Fox Run Substation Lighting Plan
 1157/69712.47KV
 TRI-STATE GENERATION & TRANSMISSION ASSOCIATION, INCORPORATED
 UPDATED BY: REV/UL 4/27/22 9:38 AM Contact: D485

Lighting Plan_V2.pdf Markup Summary

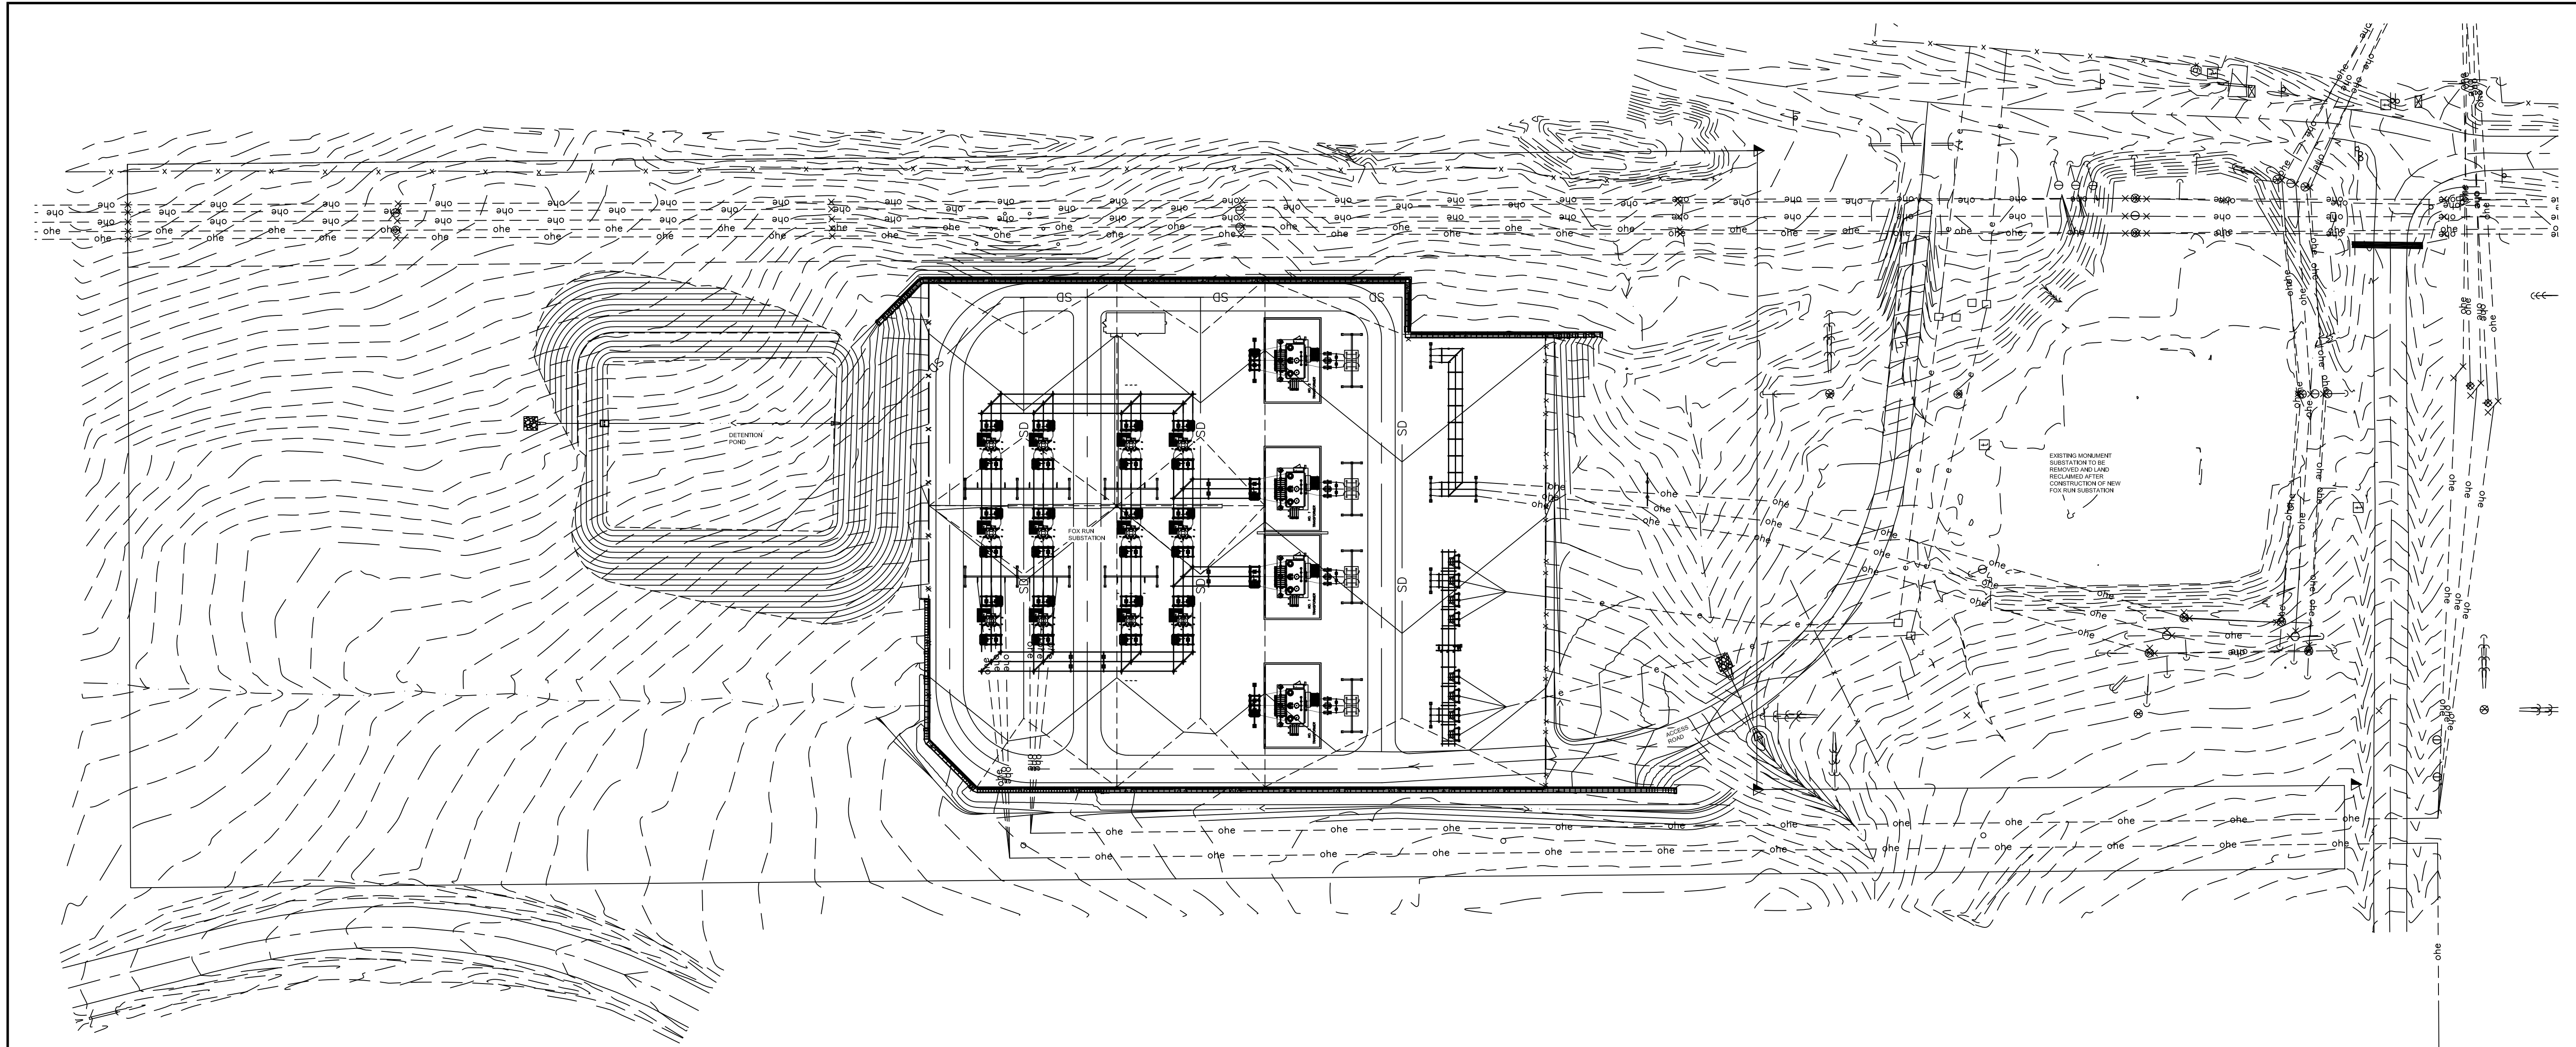
Show location and of all proposed illuminating devices

Show all property lines and neighboring zoning.

Show the building footprint for all structures depicted and labeled, if any are proposed.

Add date, north arrow and graphical scale.

Provide:
 Site address
 Applicant name (if not owner), contact telephone number, and email
 Plan preparer contact telephone number and email

Please use a color that is legible: black or blue
